DRB Application No.: 05DRB-01211 (FP)
Project Name: SUNDORO SOUTH UNIT 5
Agent: Mark Goodwin & Associates

CITY OF ALBUQUERQUE
PLANNING DEPARTMENT
AUGUST 3, 2005
DRB Comments

RE: Sundoro South Unit 5/final plat

TITLE: **SUNDORO SOUTH  
GRADING & DRAINAGE PLAN**

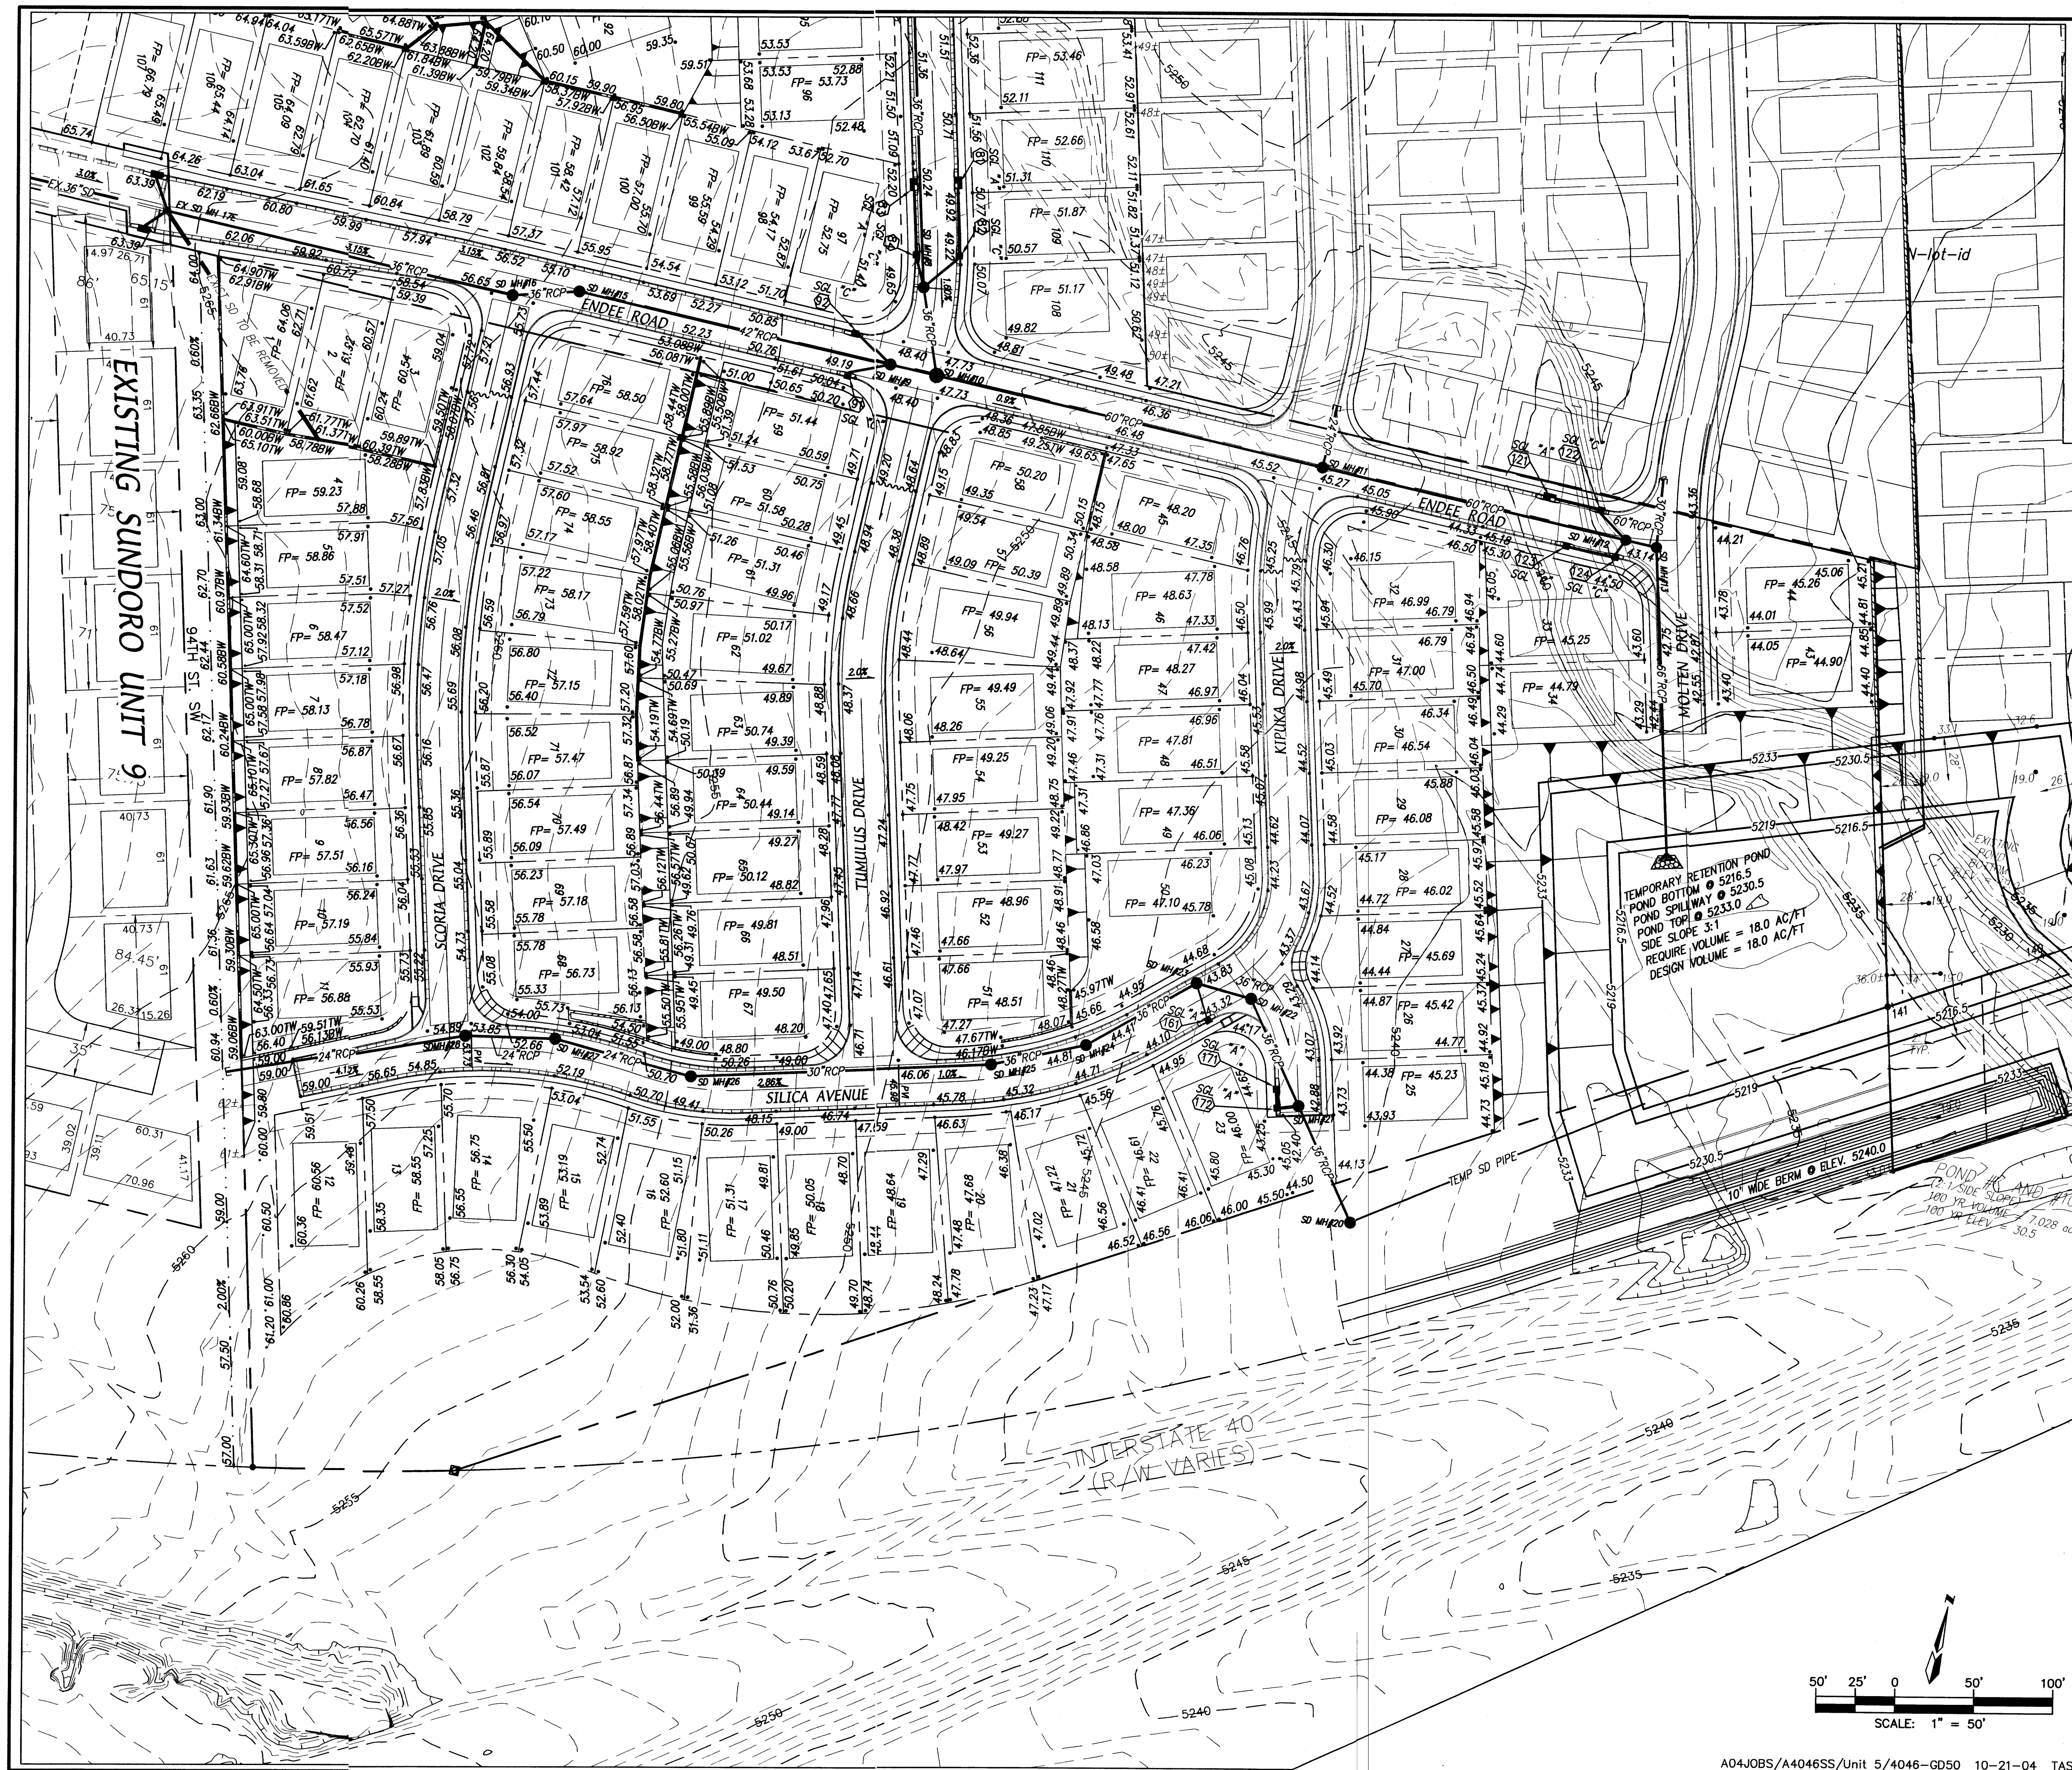
UTILITIES: Need to resolve dead-end line in Topham Ave.
DRC plans need fit at dead-end.

PLAT FOR  
**SUNDORO SOUTH SUBDIVISION**  
**UNIT 5**  
 WITHIN THE  
 TOWN OF ATRISCO GRANT  
 PROJECTED SECTION 16  
 TOWNSHIP 10 NORTH, RANGE 2 EAST, NMPM  
 CITY OF ALBUQUERQUE  
 BERNALILLO COUNTY, NEW MEXICO  
 MARCH, 2005

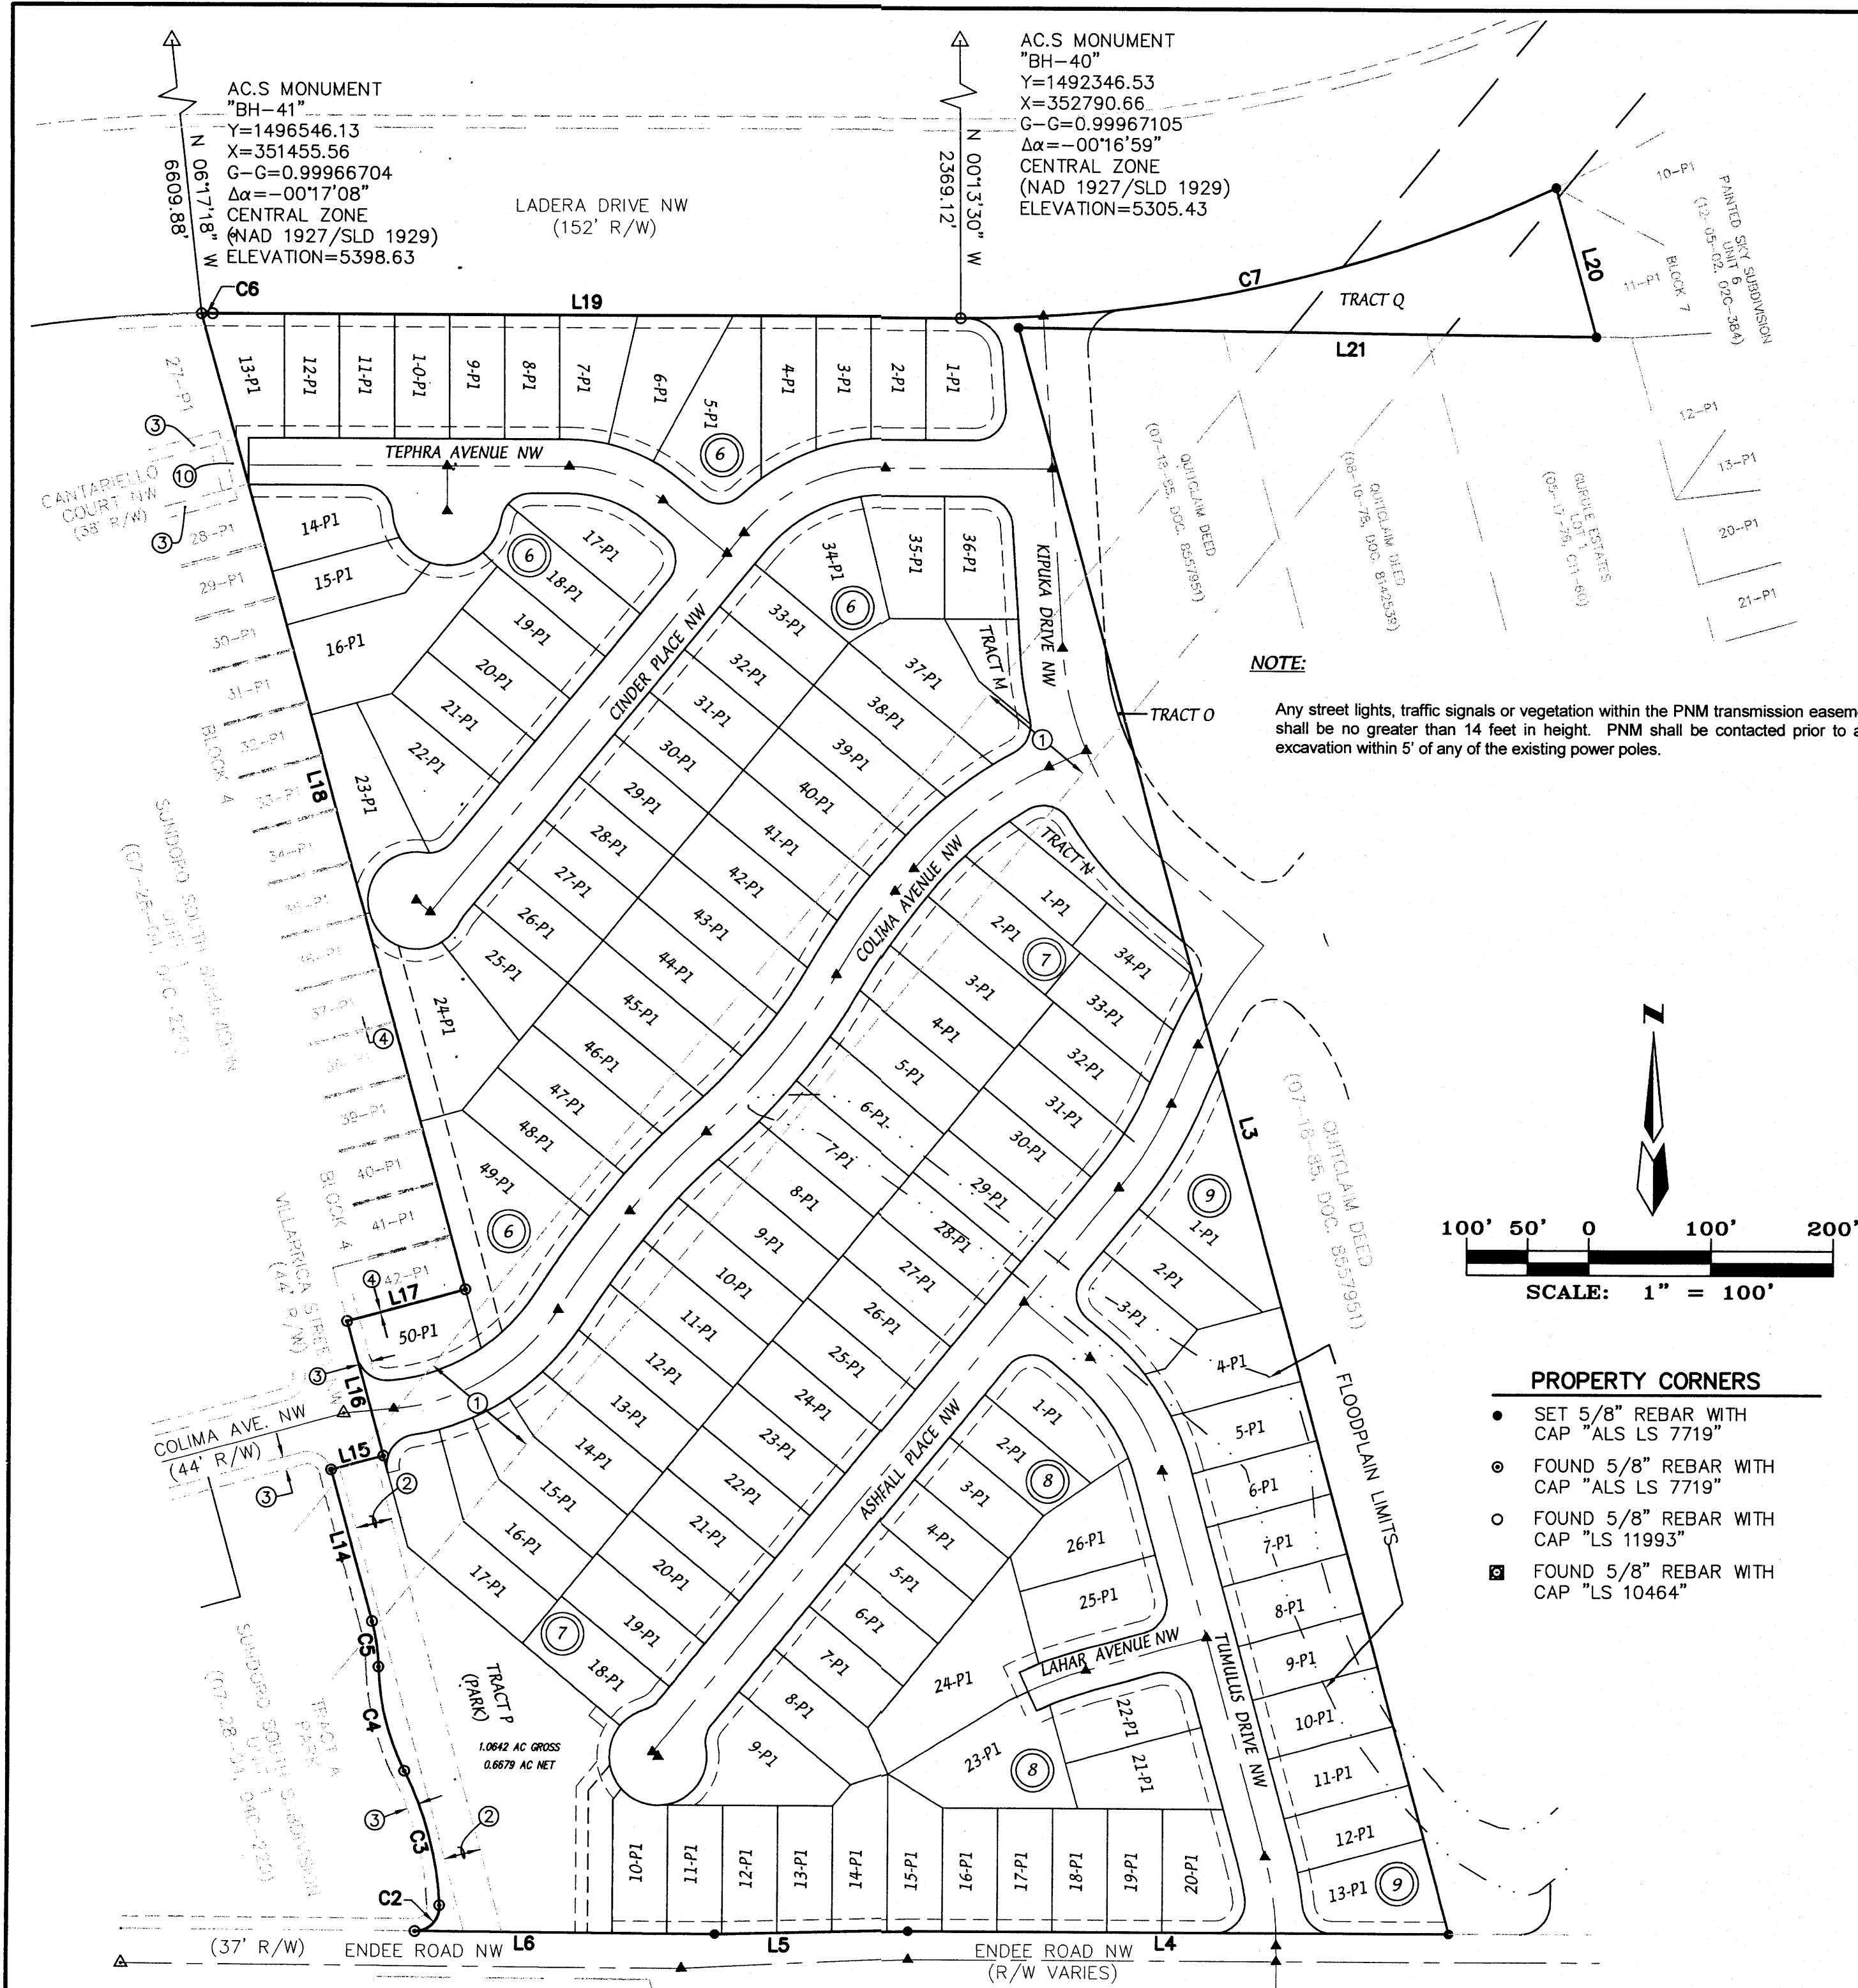
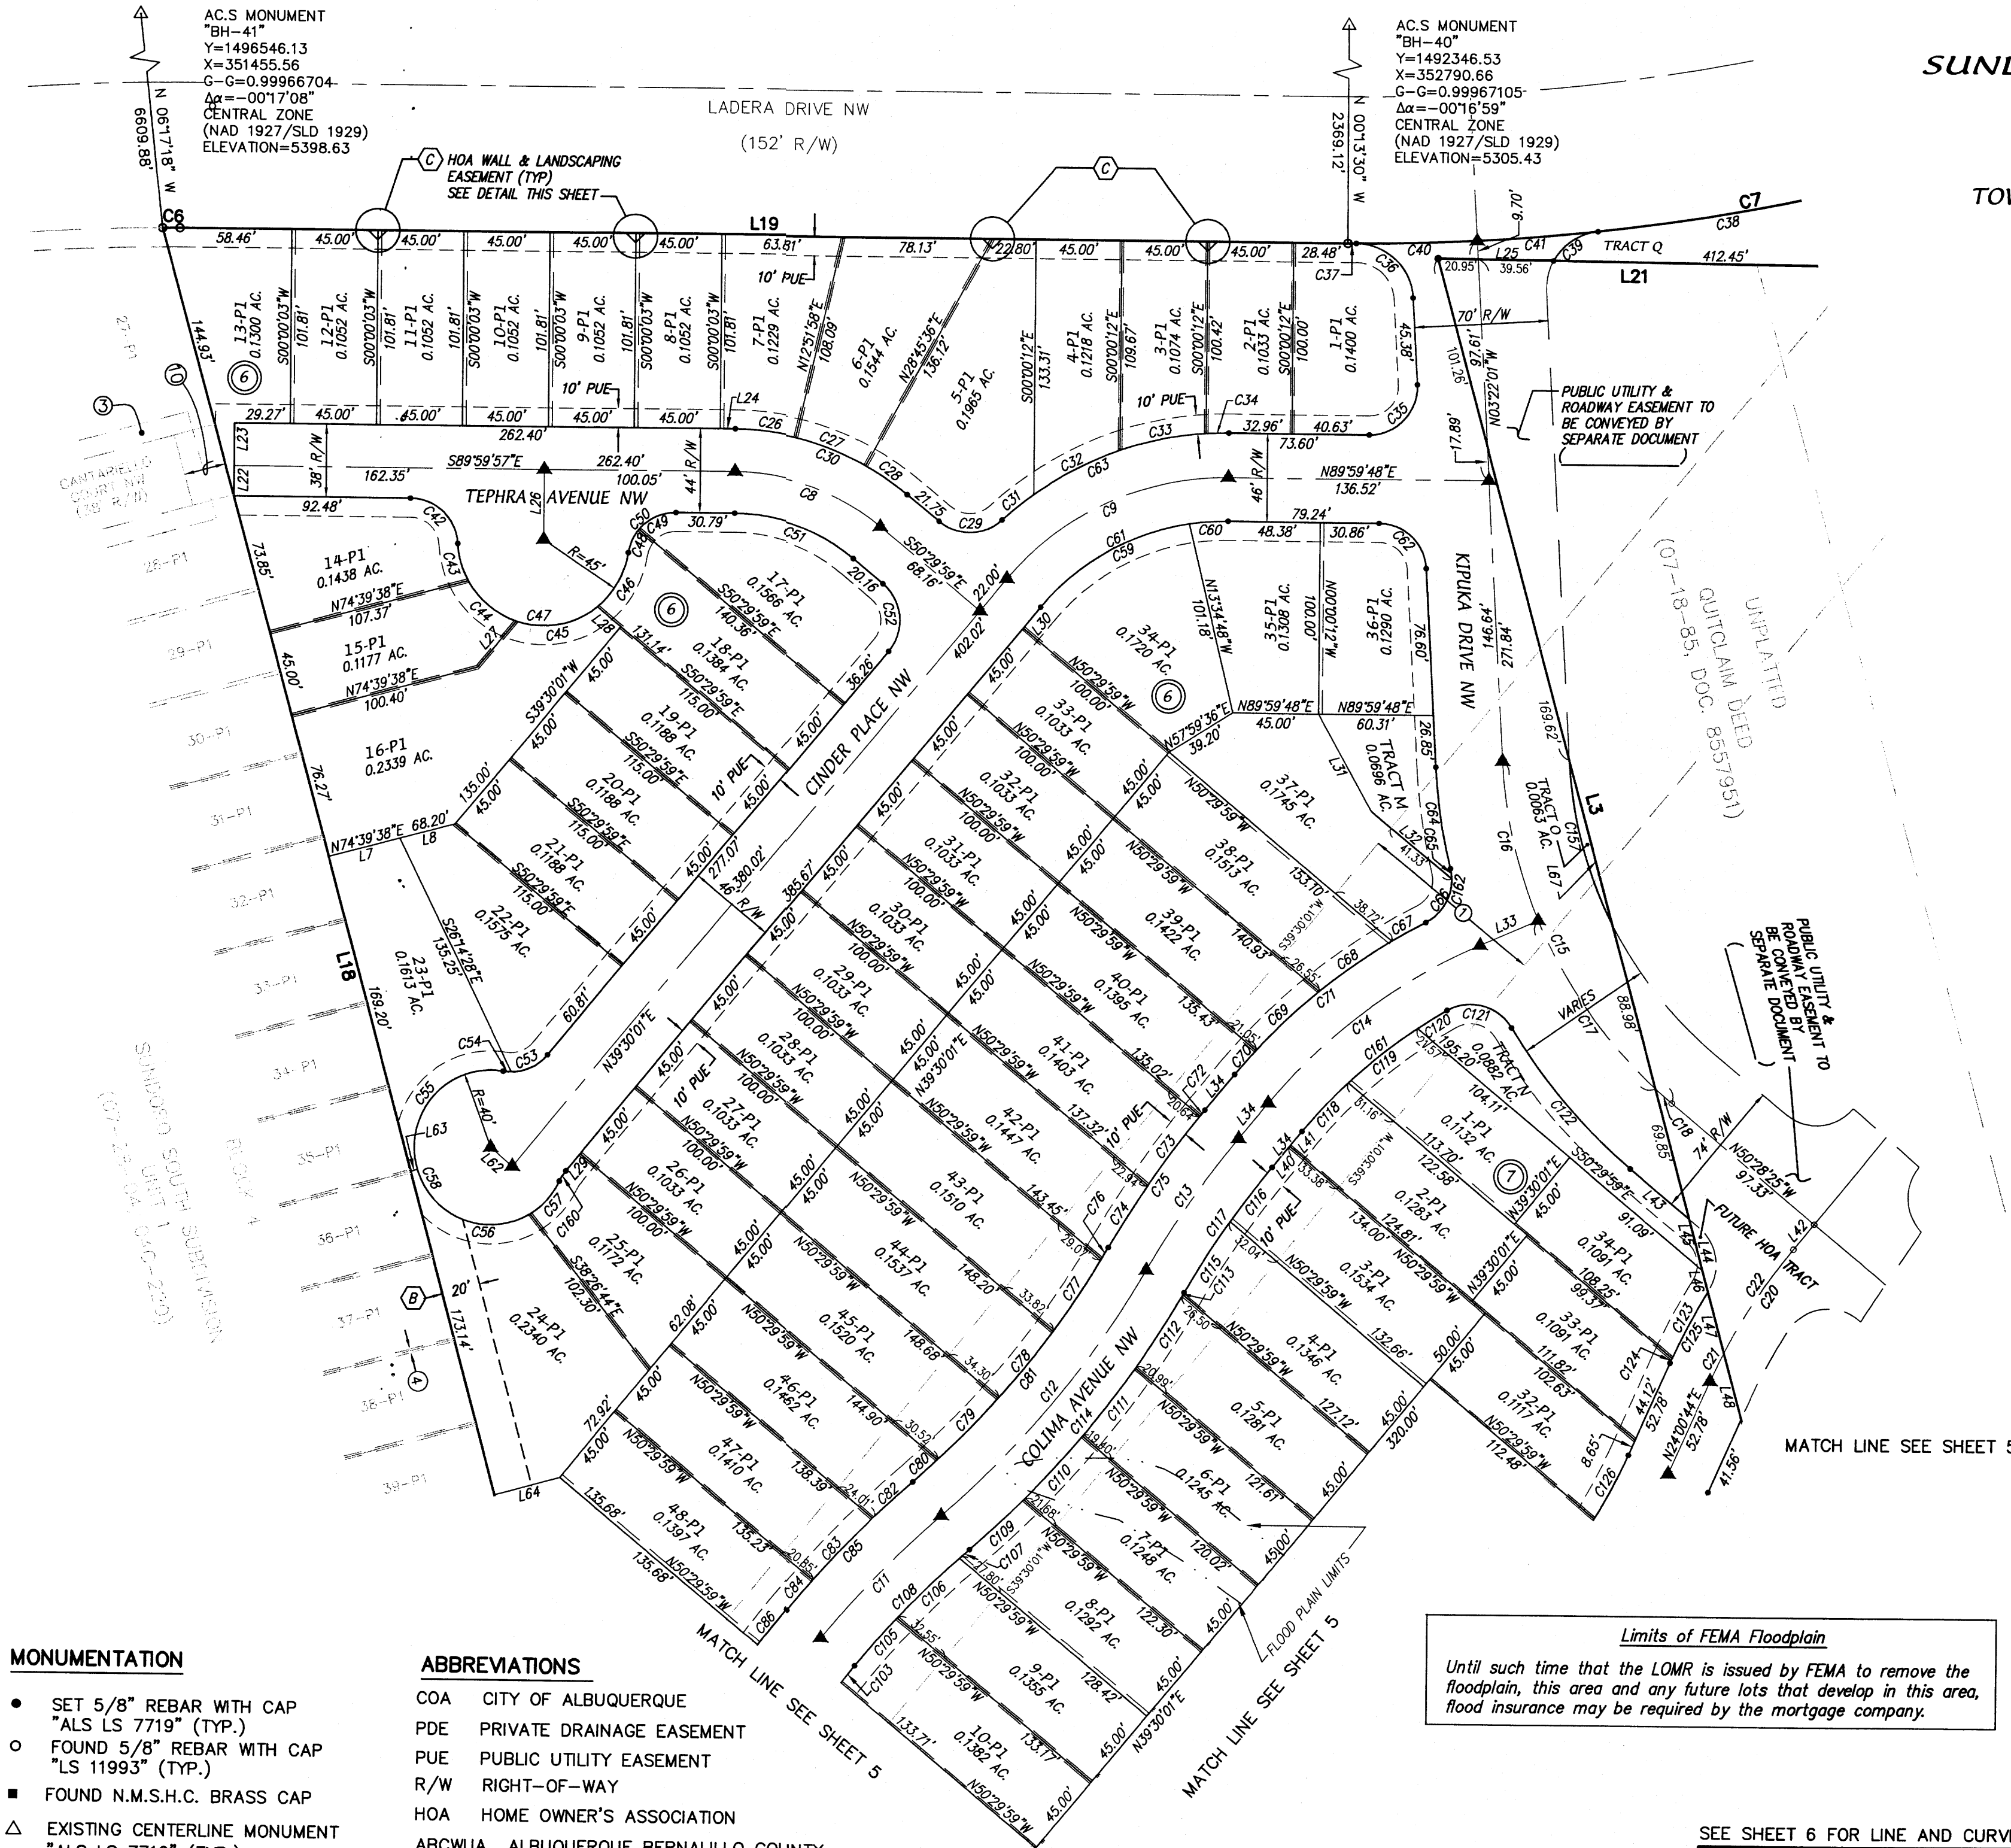
✓ Are the perimeter walls approved for this Unit?

Are there any changes since preliminary plat approval?

Have the 2 conditions of final plat been met?

✓ • Tracts O & Q were to be conveyed to the adjacent subdivision for platting.

• Right of way or easements were to be provided for Kipuka

Rec'd
leaded
Plat

AGIS dxf is approved.

Planning must record this plat. Planning will take delegation.
